STORE PROPERTY INVESTMENTS LTD

30th October 2015

Ref: A/131/15/RES – Land South of A259 and West of Mill Lane, Rustington; Parish of Angmering

scheme: Mill Lane Site
client: Store Property
drawing: Landscape Proposals
date: July '15
scale: 1:200@A1
drawing no: STORE18832 18H
drawn: DKM checked: AE

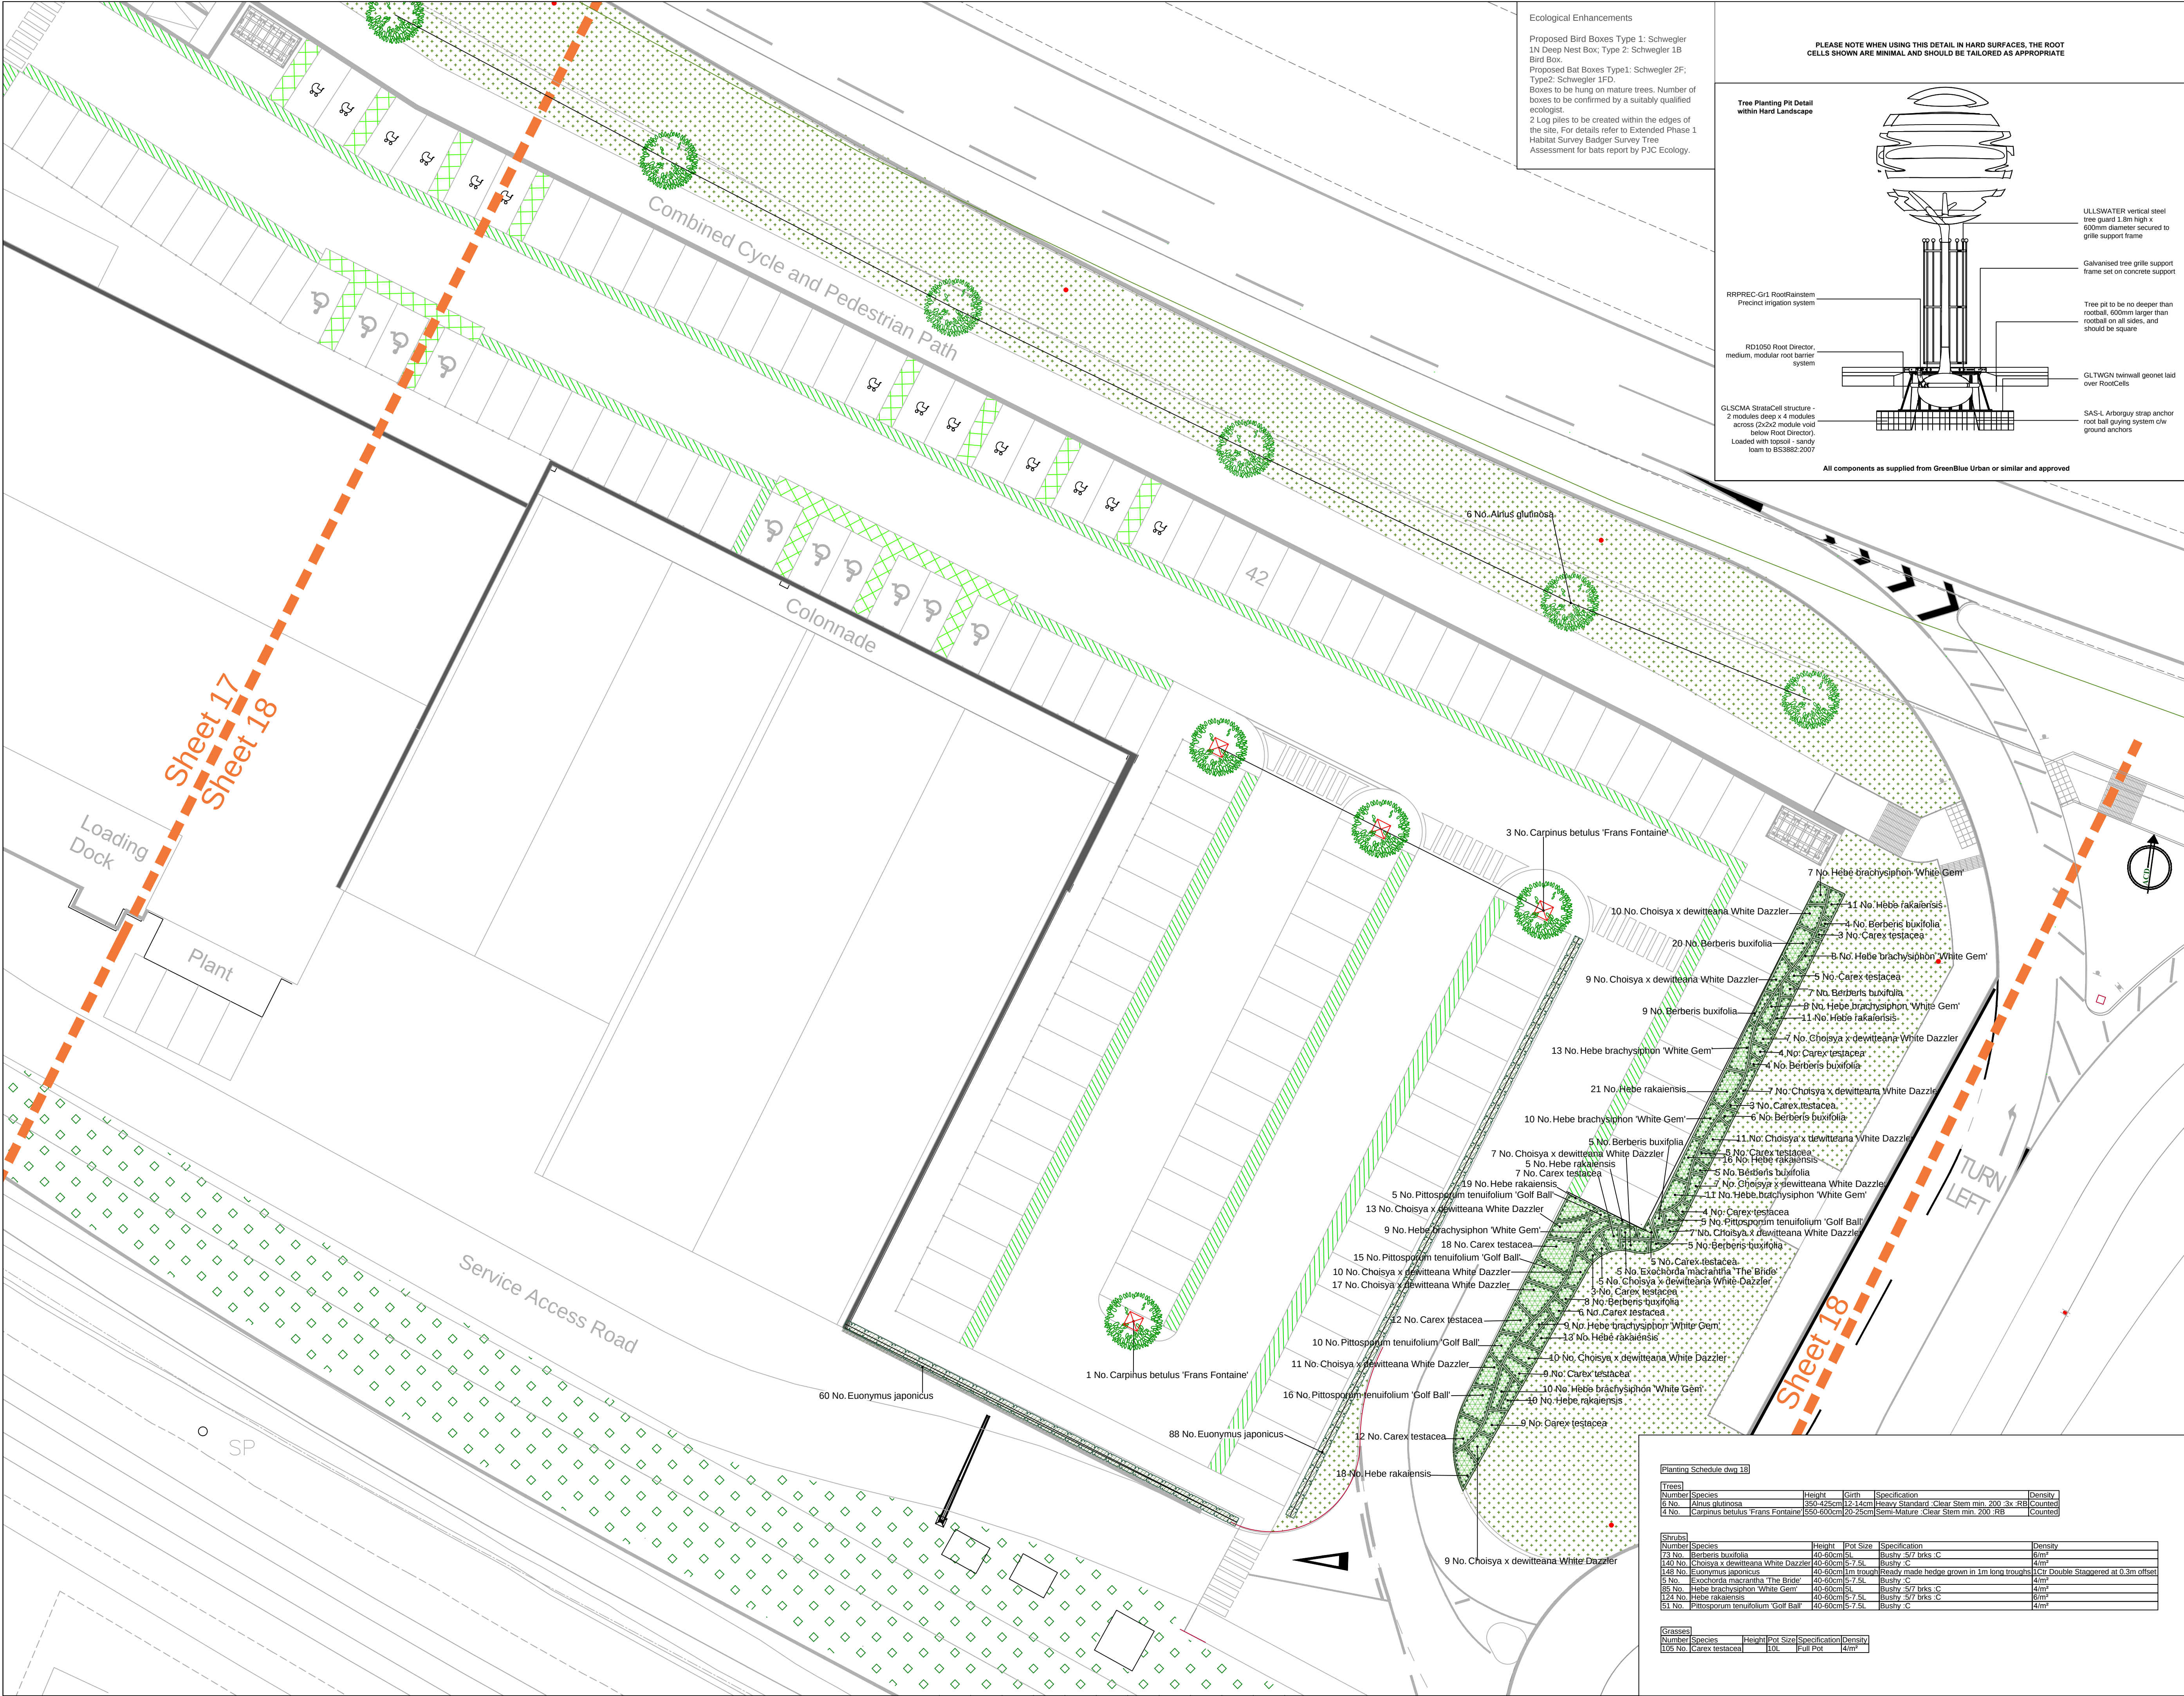
Along the road frontage with the A259, common alders (*Alnus glutinosa*) have been proposed as they provide an attractive frontage with a light and structured canopy. Angmering District Council have observed that we could provide more of these species along the western frontage of the A259 and also the Western boundary of the site, and having considered this further we agree and have consequently shown additional numbers of these species. This will result in a total of 10 *Alnus glutinosa* equally spaced along the road frontage with an additional 4 to be planted within the western landscaping area, providing a total of 14 of these species rather than 9 as originally proposed.

ADC parks and landscapes have expressed concern that the revised landscaping scheme is considerably more sparse particularly on the road frontage and rear areas. The introduction of the additional *Alnus glutinosa* will improve the road frontage and create an attractive frontage to the site.

We note that ADC are also concerned about the number of trees currently proposed overall and as such as well as the additional trees to the northern boundary, we have now significantly increased the number of proposed trees within the western planting area too. These will create an attractive and pleasant environment and additional wildlife habitat. The revised proposal will provide one new tree for each valued tree lost. Native species have been chosen for their biodiversity and wildlife value.

scheme: Mill Lane Site
Rustington
client: Store Property
drawing: Landscape Proposals
date: July '15
scale: 1:200@A1
drawing no: STORE18832 17J
drawn: DKM checked: AE

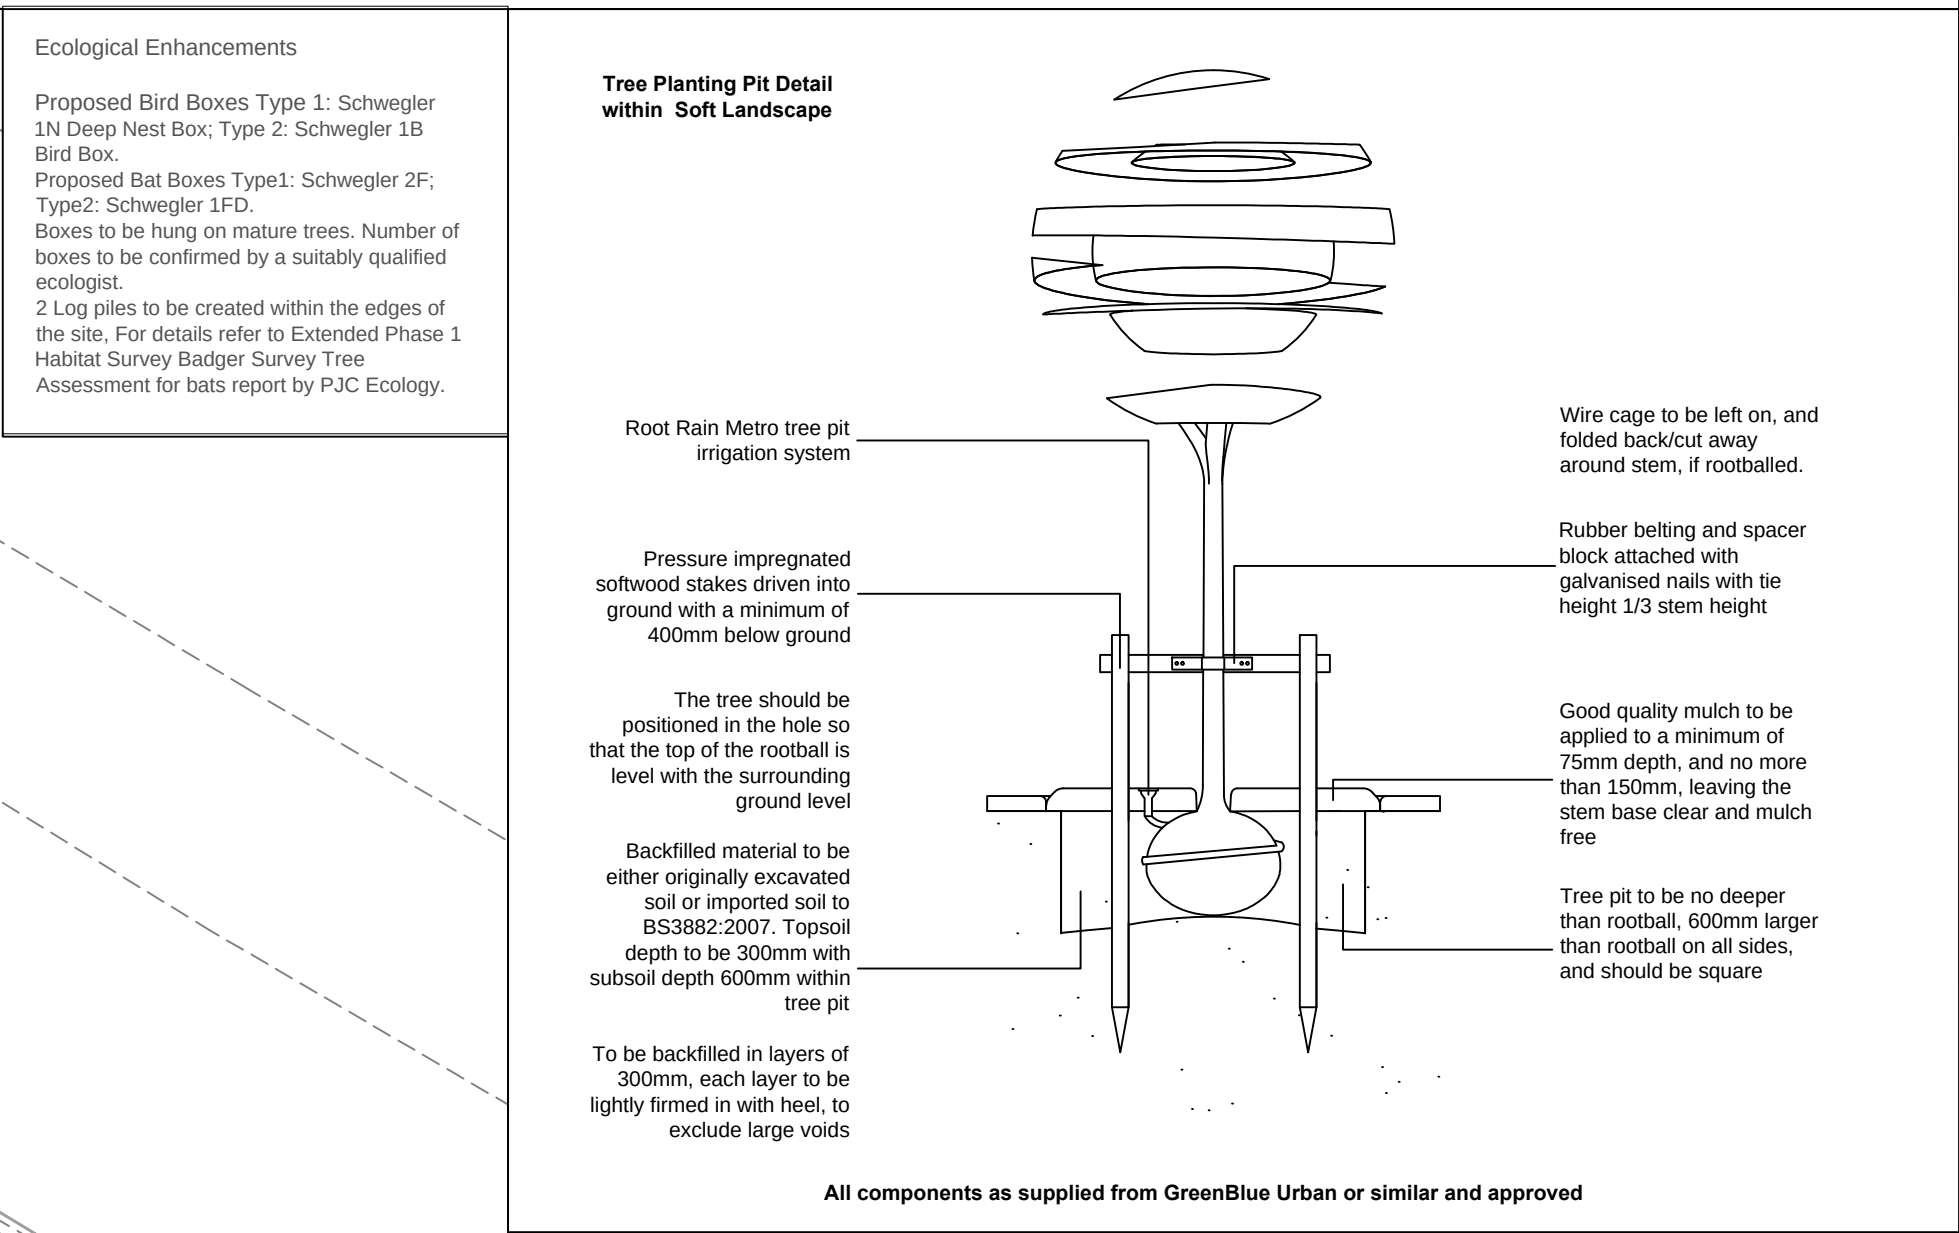
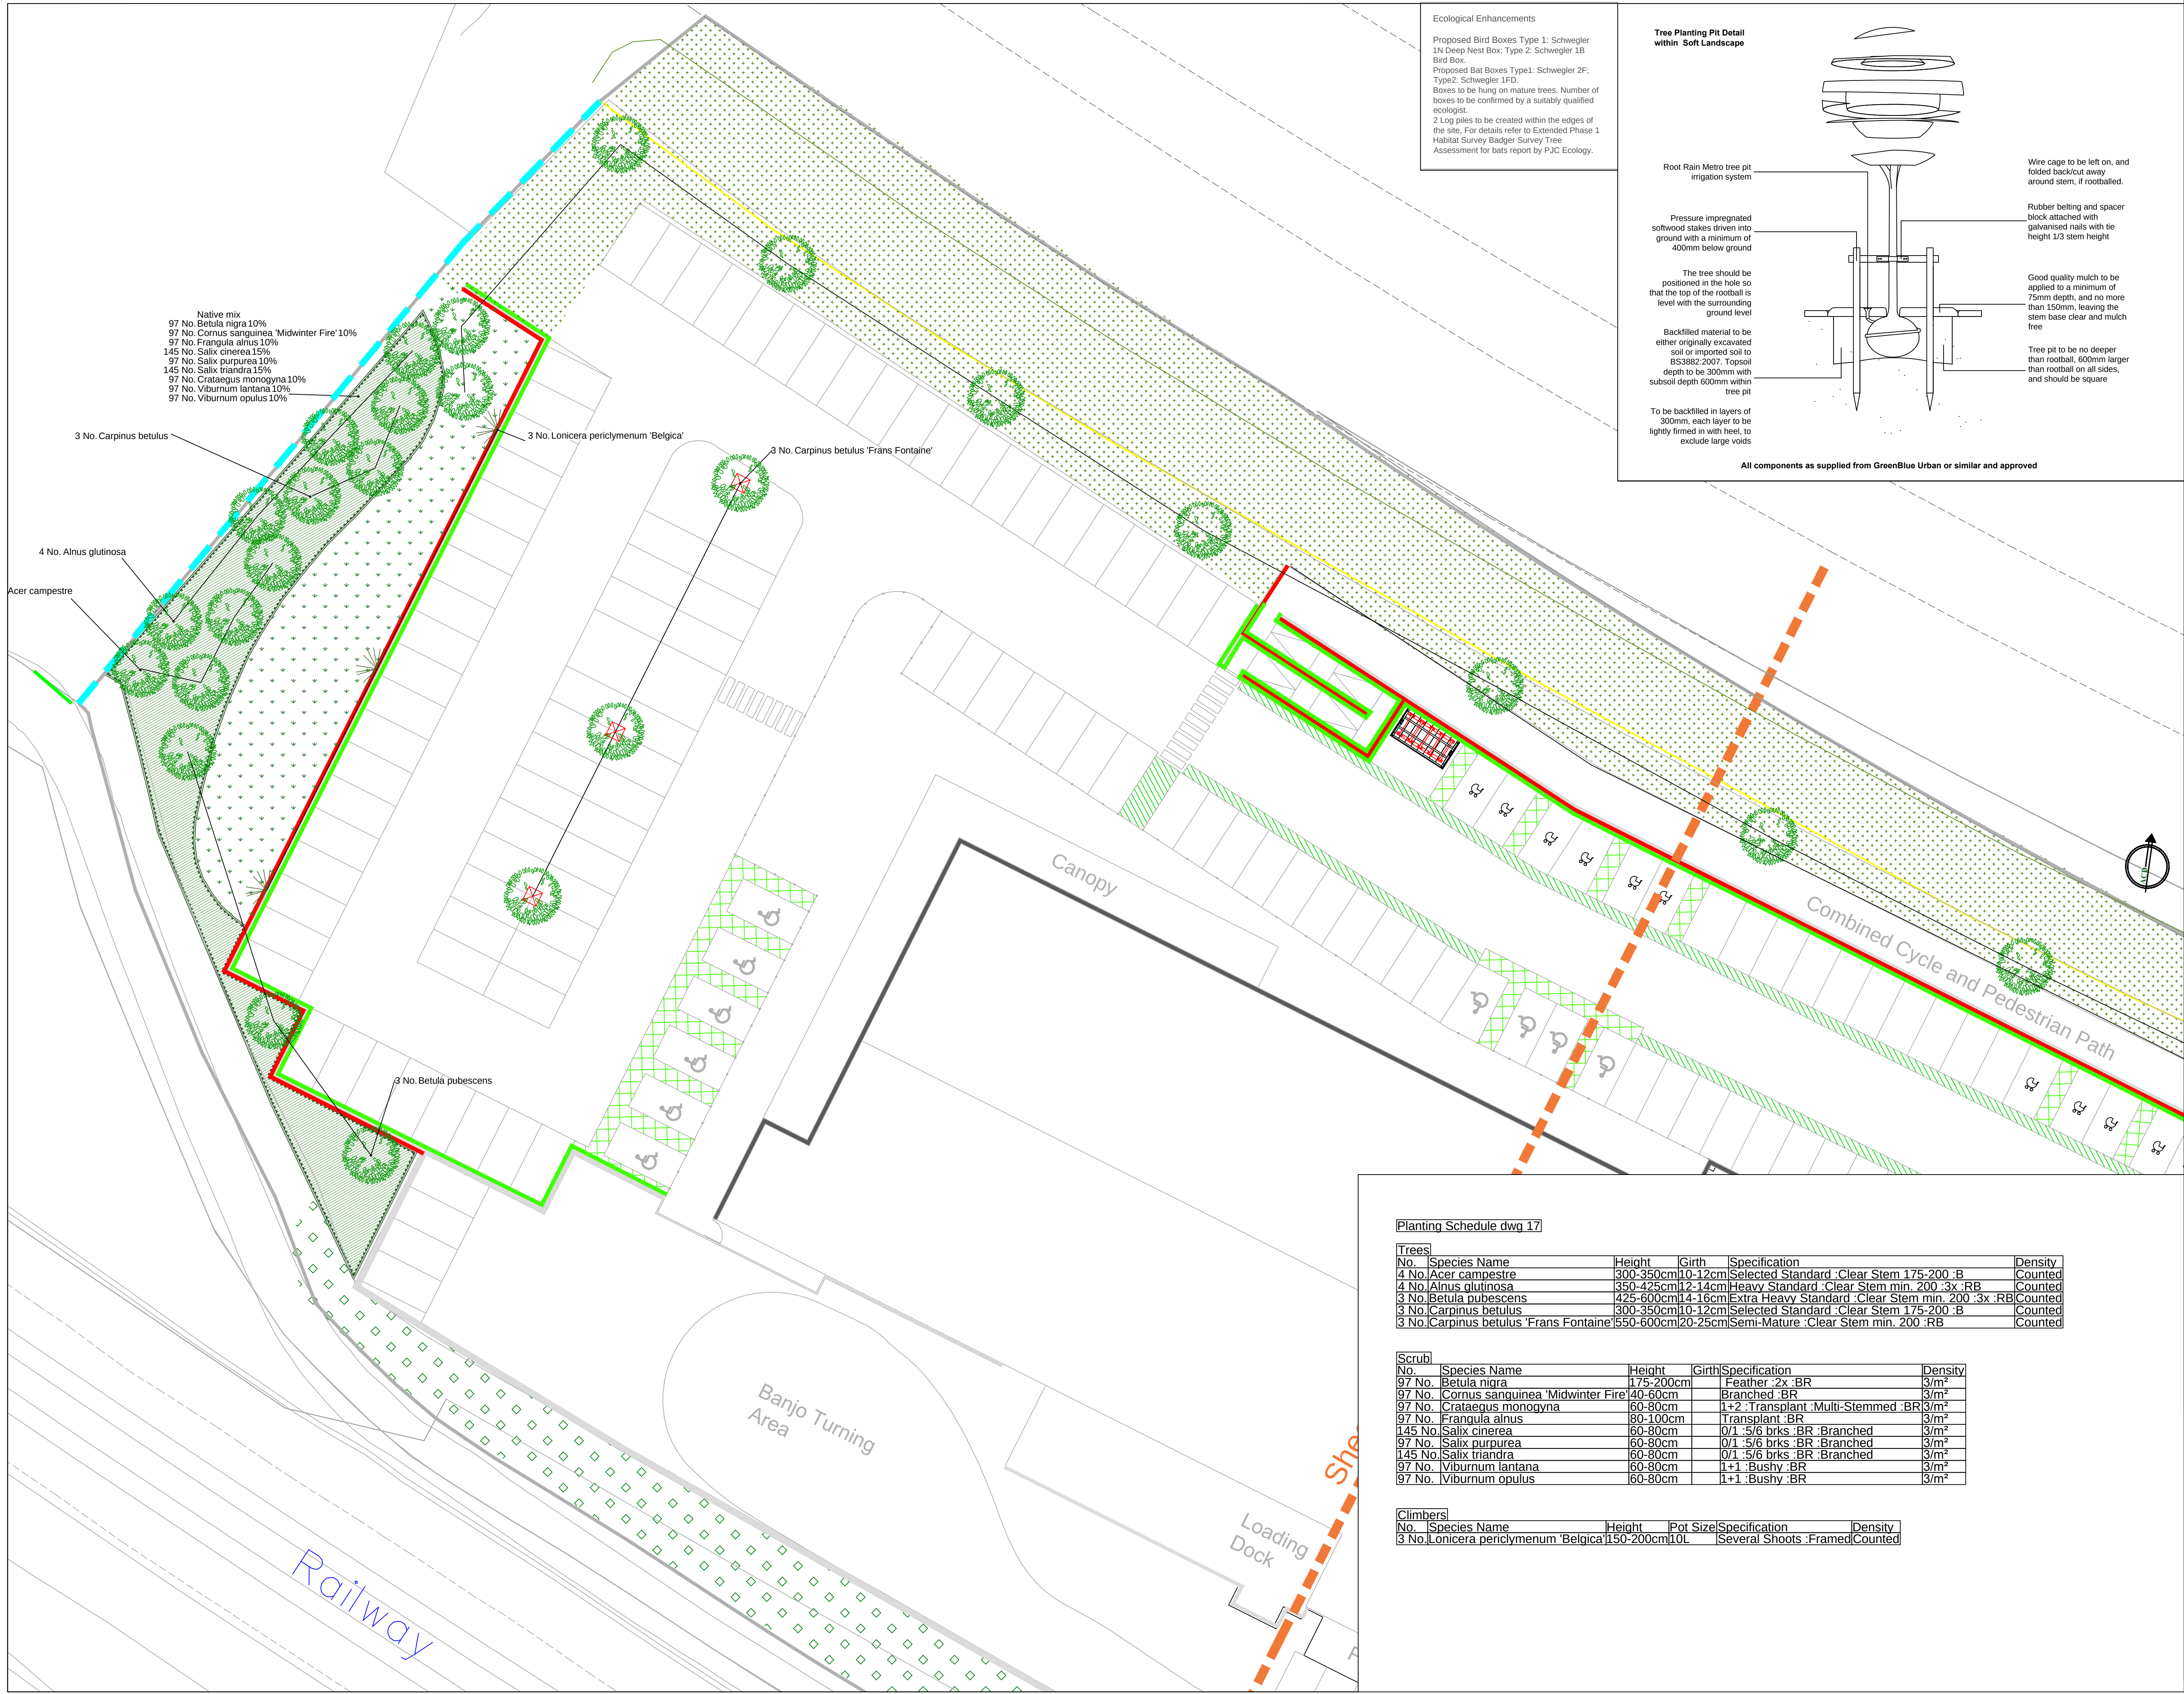
Landscaping opportunities to the rear of the site are constrained by the proximity to the railway. Network Rail require us to maintain a 3m casting way zone which must be clear of trees in order to protect Network Rail infrastructure so we will not be able to provide the trees shown on the indicative 2013 Outline proposal drawings. Our current scheme therefore proposes that this area is planted with wildflower mix which will create a biodiverse and attractive rear boundary.
